**Your Ref:** D16/4085  
**Our Ref:** MP06\_250 MOD9  
**Date:** 7<sup>th</sup> March 2017

**RE: APPLICATION FOR MODIFICATION MP06\_MOD9 – SEASIDE BOULEVARD FERN BAY**

I refer to your letter dated 12<sup>th</sup> December 2016 providing comments in relation to the above application to modify an approval.

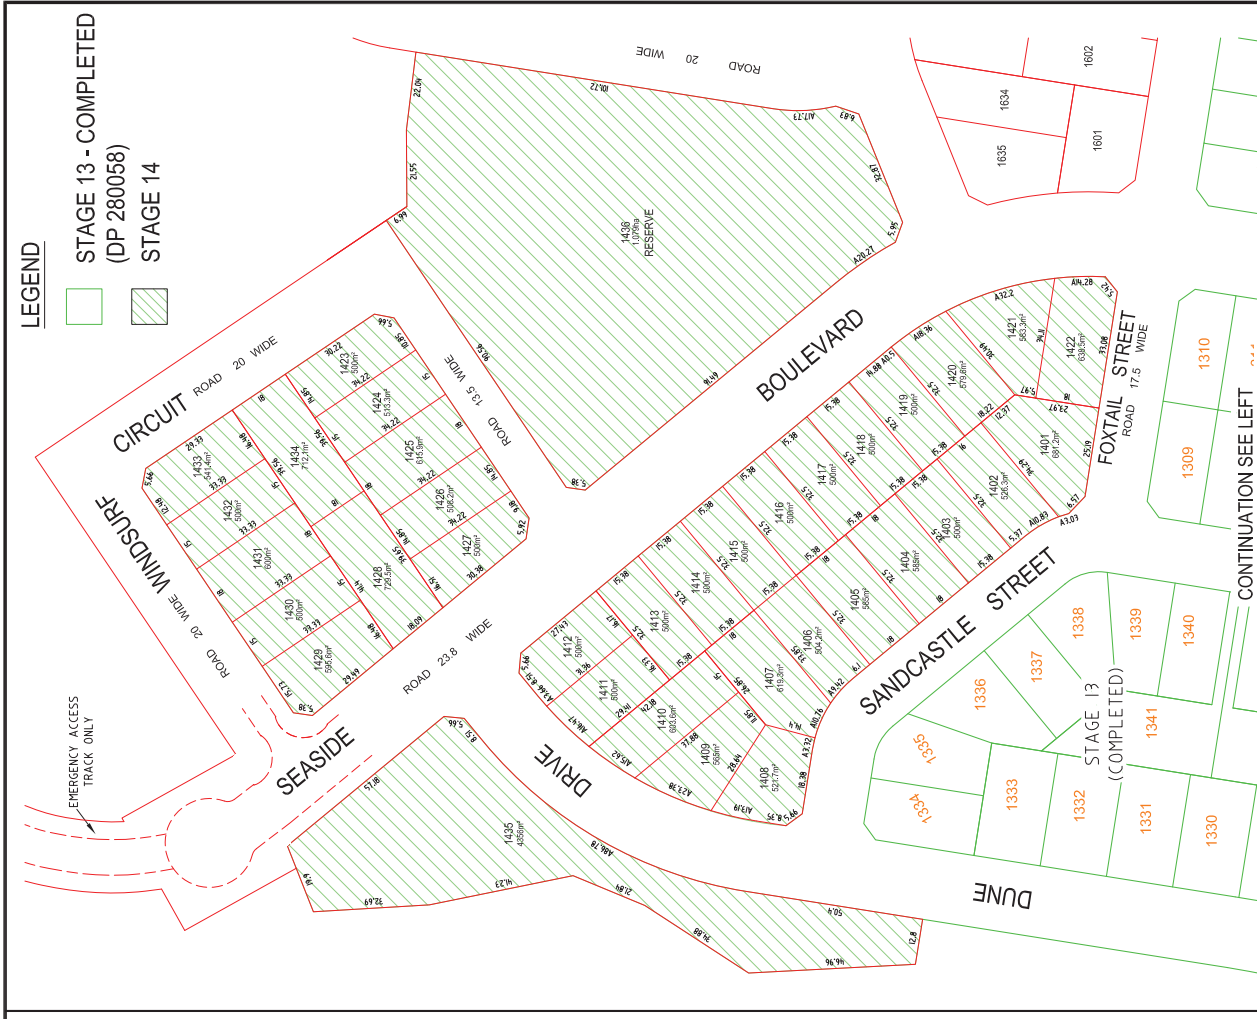
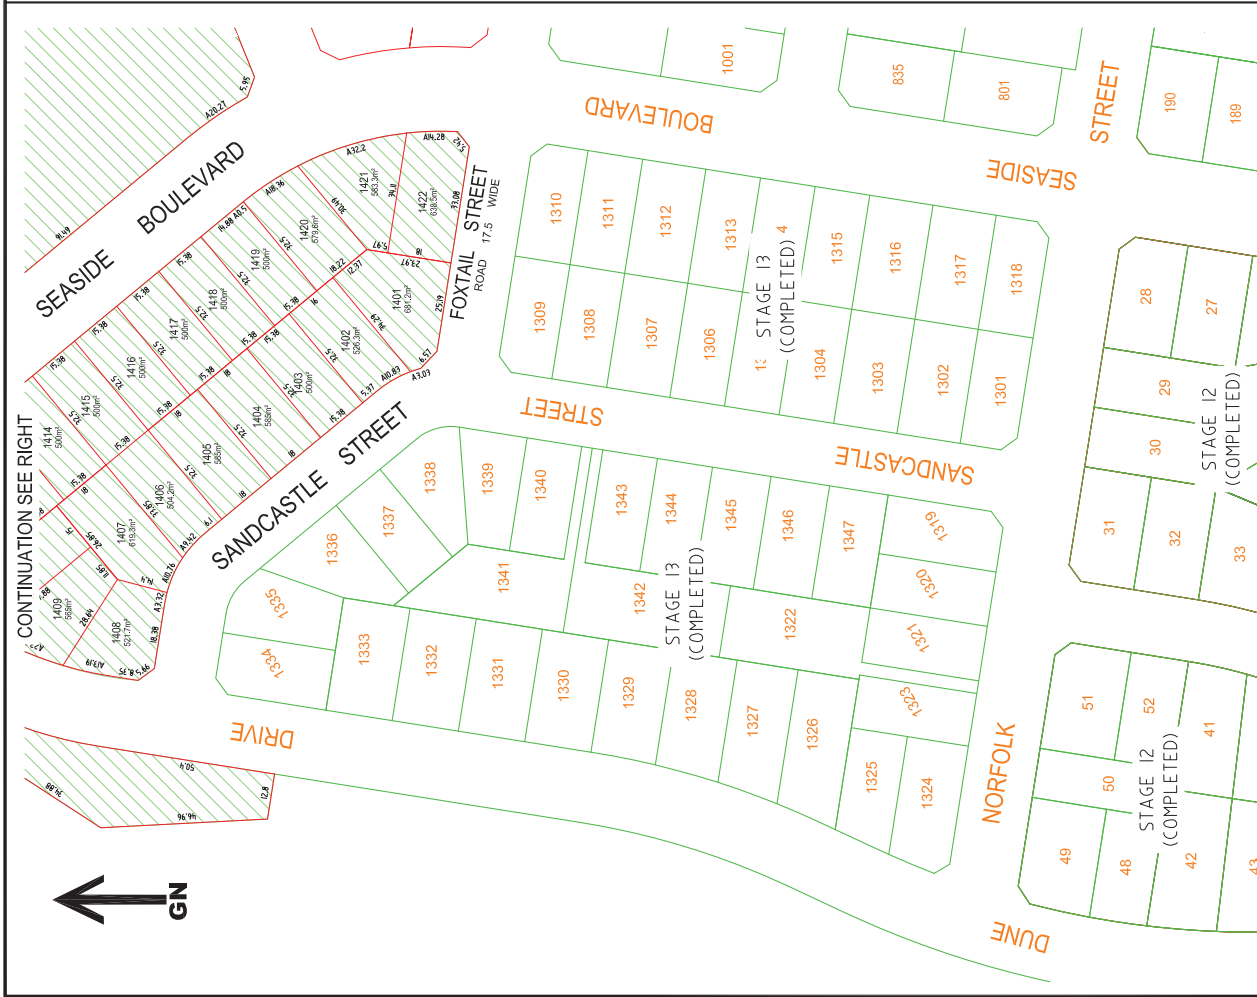
It is noted the NSW RFS has reviewed and does not support proposed modification 3, *to change a proposed secondary public road access to an emergency only access road.*

The proposed modification involves construction of a two lane emergency access road connecting the northern portion of Seaside Boulevard (Stage 14) to Nelson Bay Road. The road is to be gated and provides two way access allowing the evacuation of residents and safe operational access for emergency services during a bushfire. Similar to all roads within the Seaside Village, the emergency access road will be dedicated to Council.

- The proposed road is to be a two-wheel drive all weather road, providing fire fighters with safe access to structures;
- The proposed road will be 8m wide for the entire length and designed in accordance with the local council (Port Stephens) engineering specifications for local roads;

- The proposed access is less than 200m long (measured from the end of Stage 14 – Seaside Boulevard to the Nelson Bay Road reserve);
- The proposed road is two-way and compliant with the PBP 2006 acceptable solution construction requirements;
- The capacity of the proposed road surface is sufficient to carry fully loaded firefighting vehicles alongside retreating residents;
- The proposed road will be clearly signposted with emergency service personnel (e.g. NSW Rural Fire Service, NSW Fire and Rescue or NSW Police) managing any emergency evacuation traffic control of retreating residents exiting the residential area;
- Access to the reticulated water supply (minimum 2 hydrants along access road) will be clear and unobstructed; and
- The threat of obstruction is minimised as the proposed road is to be gated with no parking permitted at any time.

Furthermore, all vegetation up to 20m on either side of access road within Seaside Village has been cleared and will be maintained in perpetuity as an inner protection area. **Plates 1-4** show the location of the existing formed access road and the extent of vegetation clearing either side. The existing road will be widened to 8m and sealed to ensure continued all-weather access.

The proposed modification seeks to limit the use of the road for emergency situations only, which remains in accordance with the PBP 2006. Accordingly, we support the modification and are of the opinion that during emergency situations, the access road will provide safe operational access for emergency service personnel while residents are evacuating. It is acknowledged that as the gates can only be unlocked by authorised persons; namely emergency service personnel, all vehicles using the access road will do so under the control of emergency services; including when egressing onto Nelson Bay Road. It is likely that all traffic in the local area will be directed away from the bushfire source; and given the approved road was restricted to left in/ left out; it is considered safer for vehicles to enter onto Nelson Bay Road in either direction only under the control of emergency services.
